A428 Black Cat to Caxton Gibbet improvements

9.48 Pre-commencement Plan

**A428 Black Cat to Caxton Gibbet
improvements**
Development Consent Order 202[]

Regulation Reference:	Rule 8(1)(k)
Planning Inspectorate Scheme Reference	TR010044
Application Document Reference	TR010044/EXAM/9.48
Author	A428 Black Cat to Caxton Gibbet improvements Project Team, National Highways

### 2.2 Pre-construction mitigation works

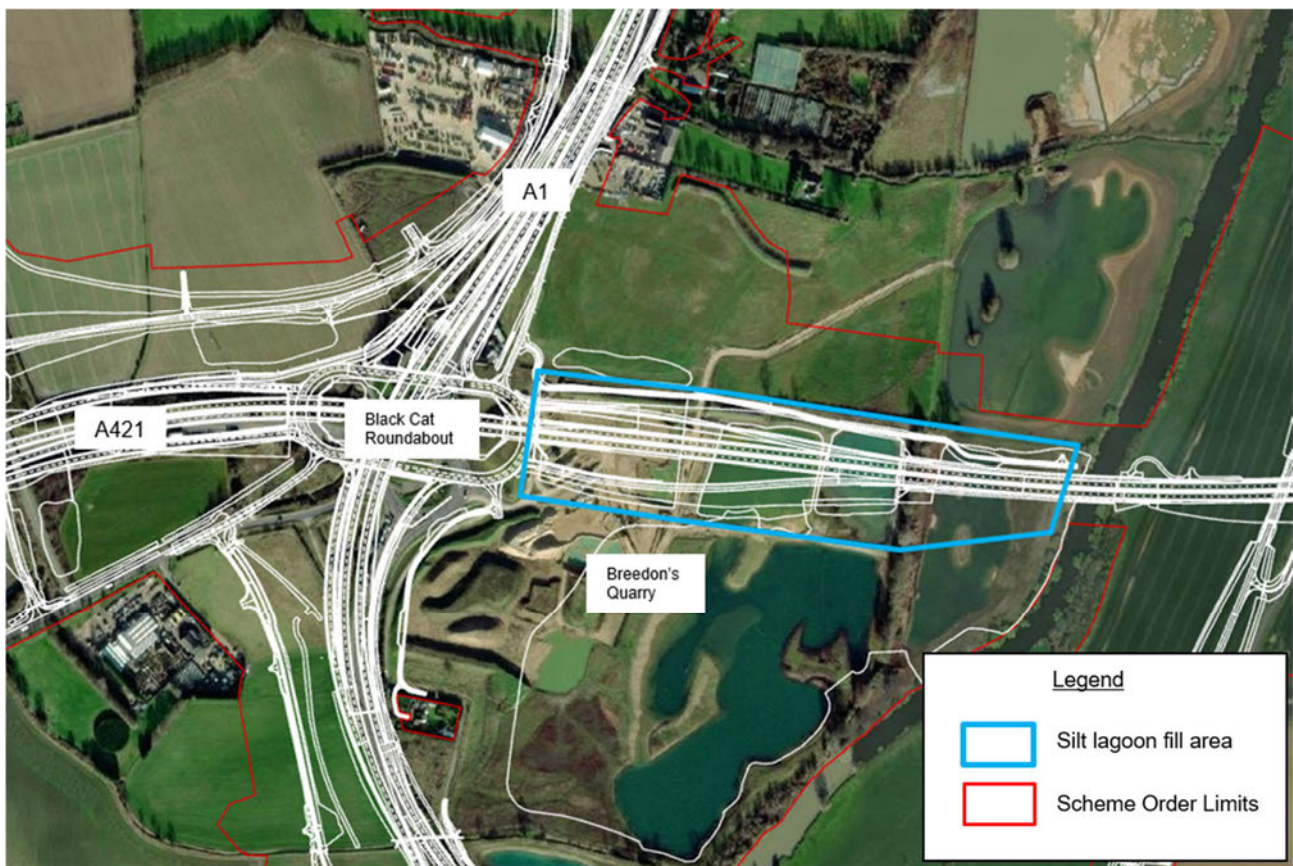
Commented [DA4]: It is unclear where exactly the fencing will be installed. Further clarification is required, including a table listing when / where the fencing will be installed, including a constraints map showing the location. Such as specified distances from Badger sett, watercourse, birds nest. This should include fencing around the section of Protected Road Verge S8, Brockley Road.

Commented [DA5R4]: If these details are not yet known, the Councils seek a mechanism to be consulted at to such details as the scheme progresses

Commented [DA6]: Any other bat mitigation measures should be implemented. Including veteranisation of trees and any protection of existing flight-line (should gaps be formed during construction)

Commented [DA7]: Why is this limited to the Order Limits? Barn Owl boxes must be installed pre-construction, but must be 1.5km away from the Order Limits. Please update to include Barn Owl
